AB/22/22/PL

61 Maltravers Street Arundel BN18 9BQ

Variation of condition 2 imposed under AB/109/18/HH relating to approved plans.

DRAWING
Proposed Plans
Proposed Visualisations

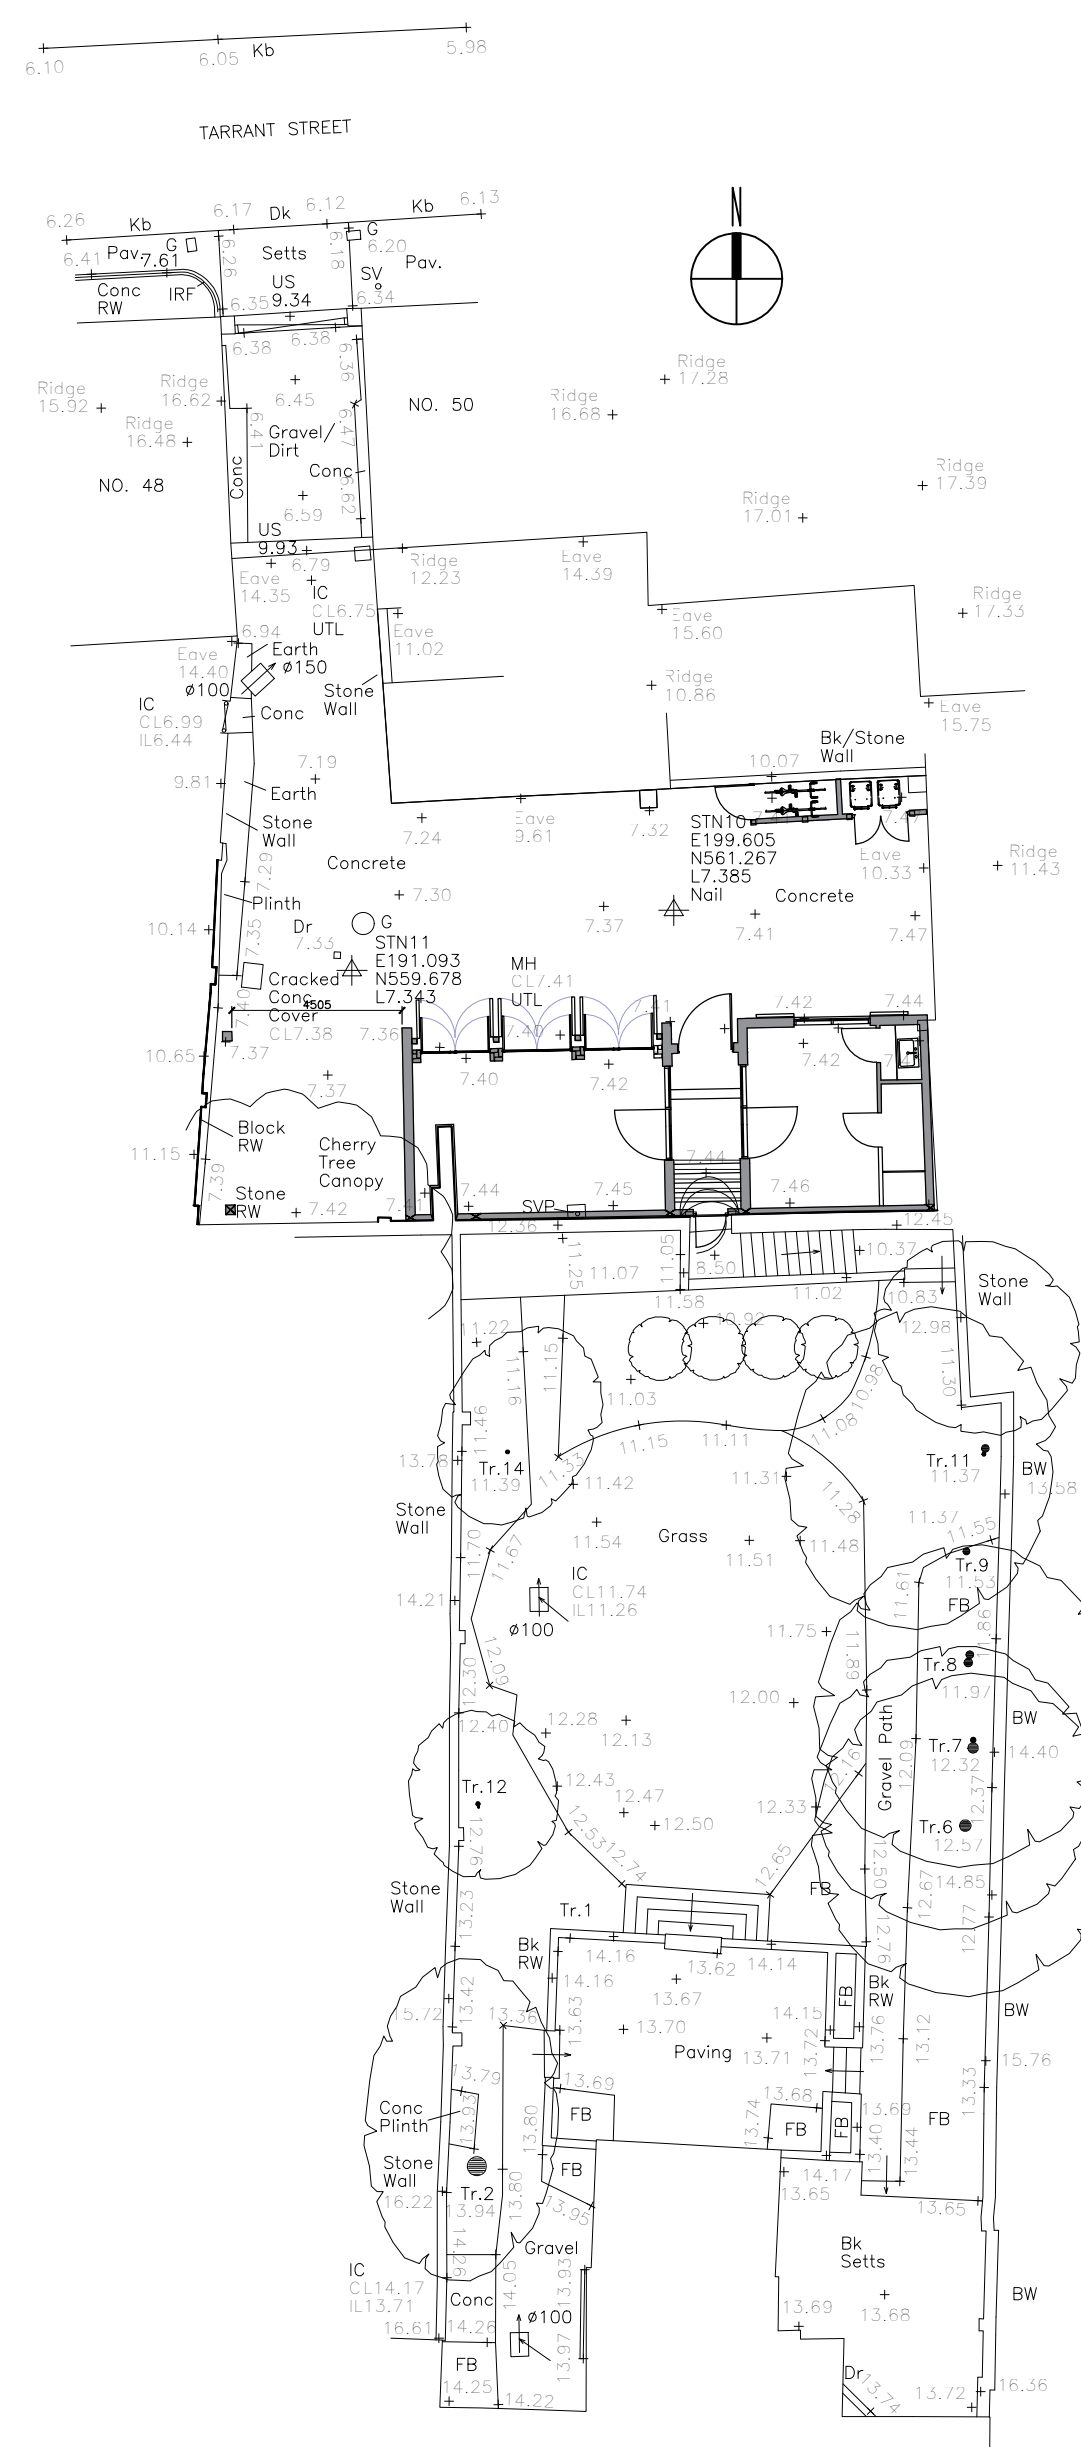
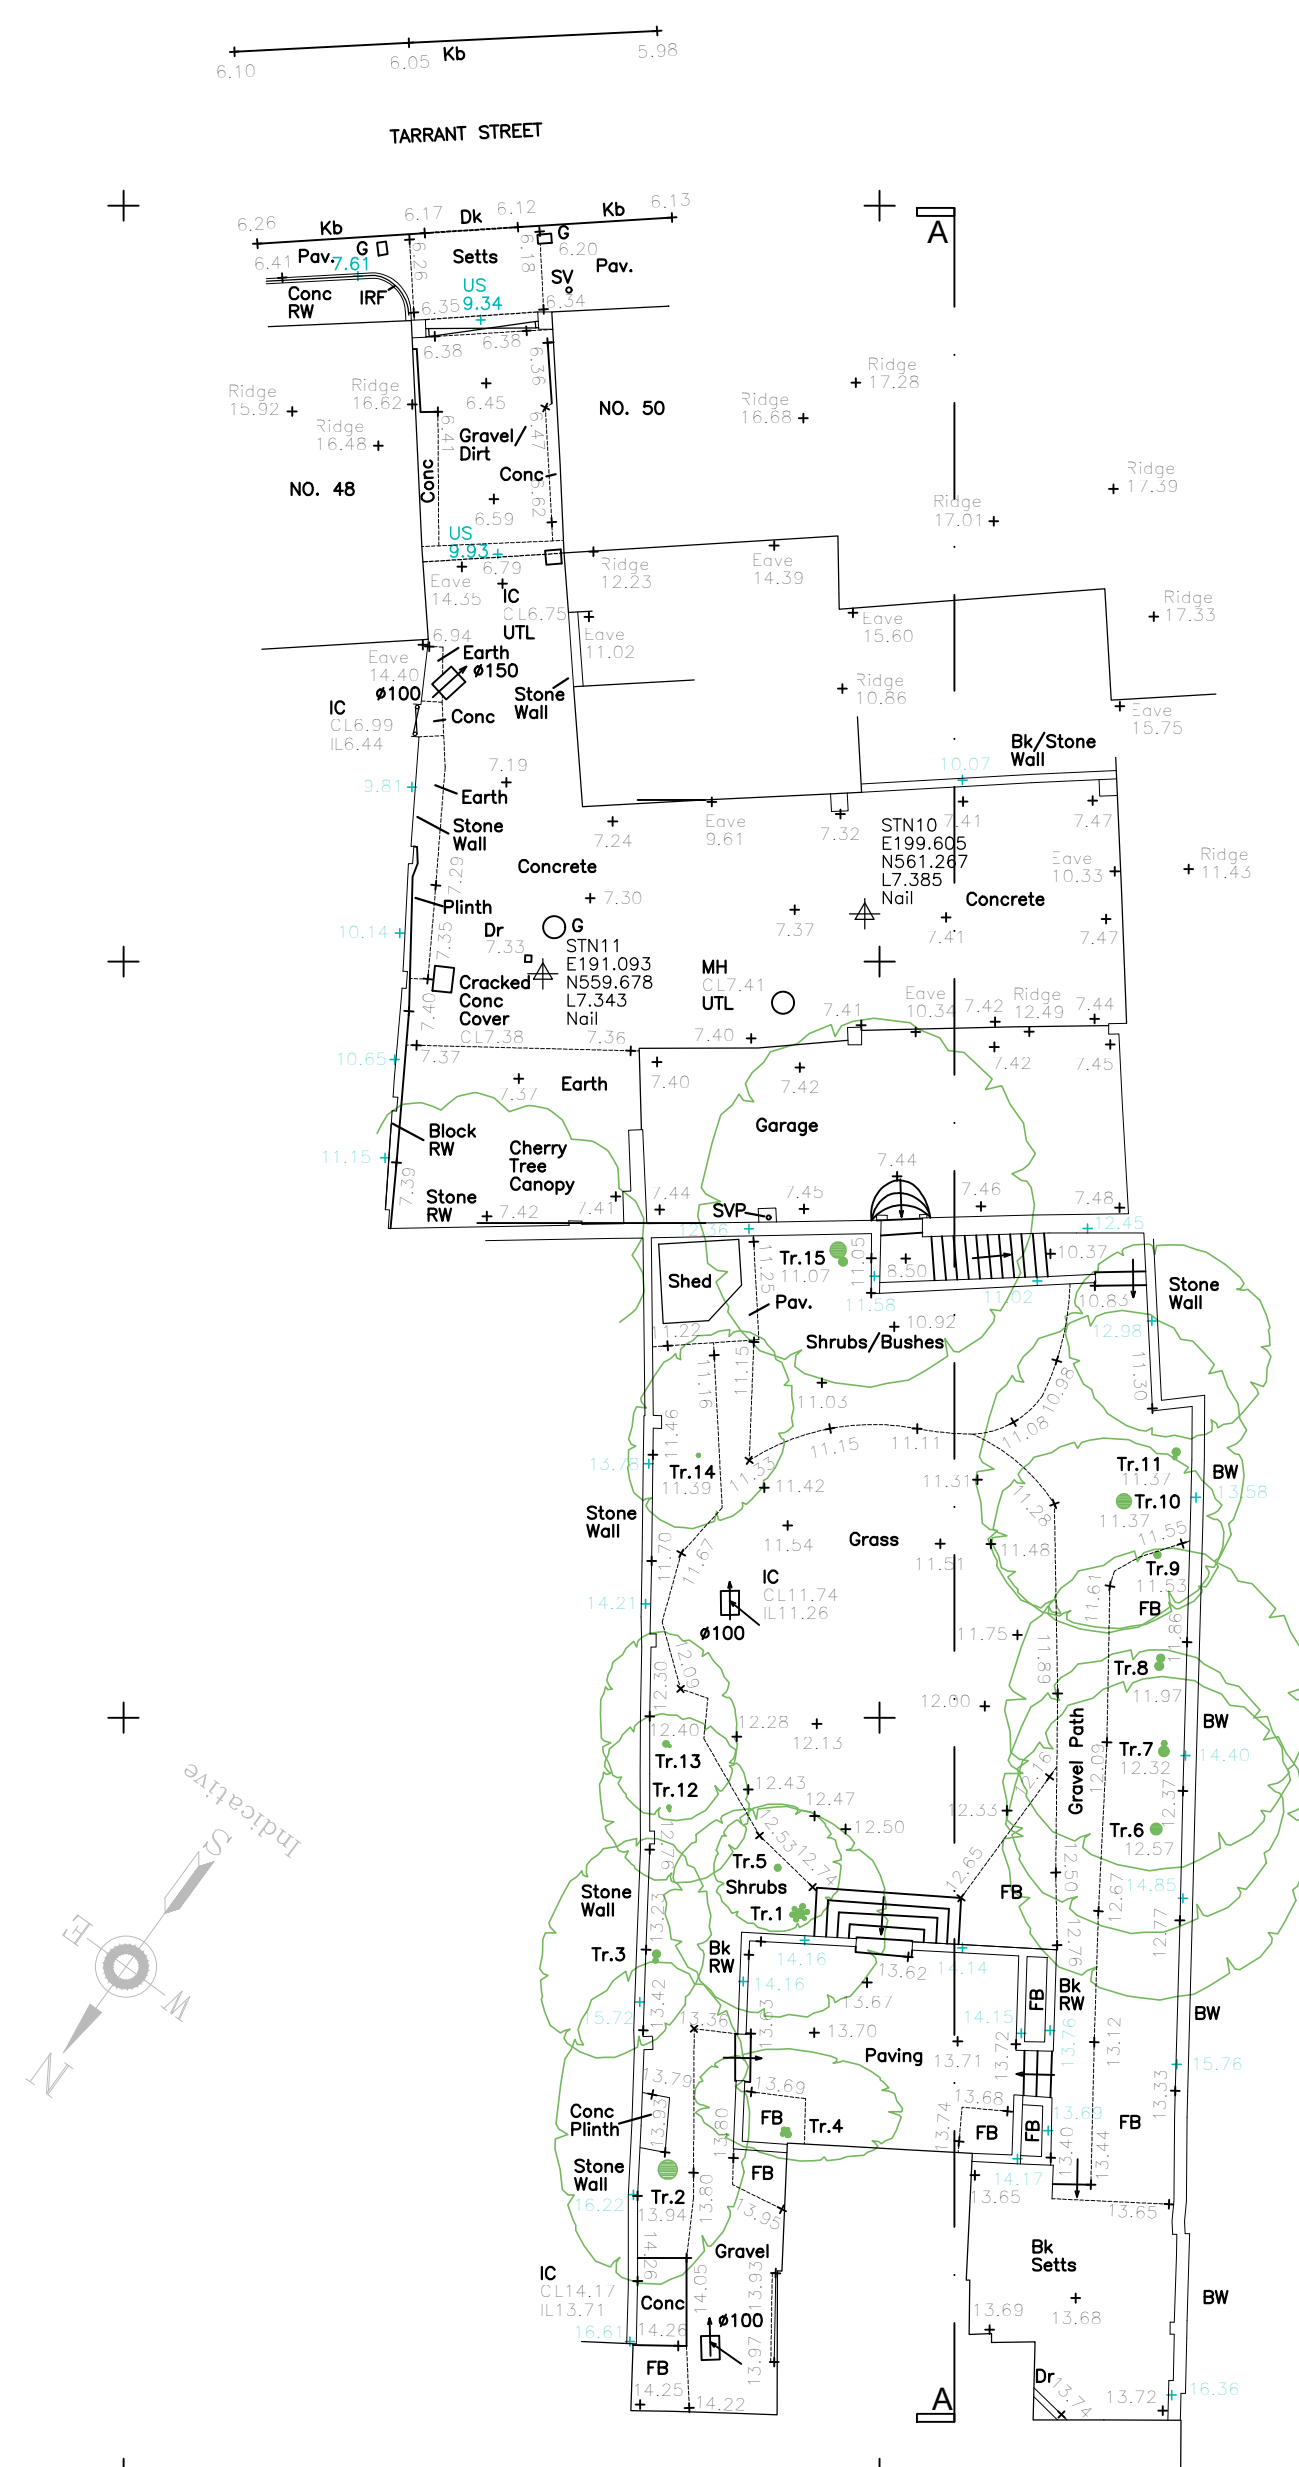
The proposal is to vary the plans approved under application AB/109/18/HH. Based on the plans provided as part of this application it is not fully clear how the plans differ, and as a result I have had to compare them with the previously approved ones. It would have helped if a statement had been provided identifying the relevant changes. It would appear that there are a number of changes to the roof structure which would affect its appearance. However, these changes are not considered to cause harm and would be located so as to not be visible from Tarrant Street.

As before, the proposed design appears to draw upon a concept of a garage/stabling block through the use of simple façade treatment and the incorporation of a series of closing garage style doors. This concept reflects the existing character of the site, along with the previous use. The success of such an element of the design will depend upon the detailing of the window/doors. It is suggested that the glazing should be set back so as to create a shadow line, which reduces the impact of the glazing. Full details of the materials, proposed joinery and windows/doors and their treatment should be provided if you are minded to approve the application. These details can be provided by way of condition.
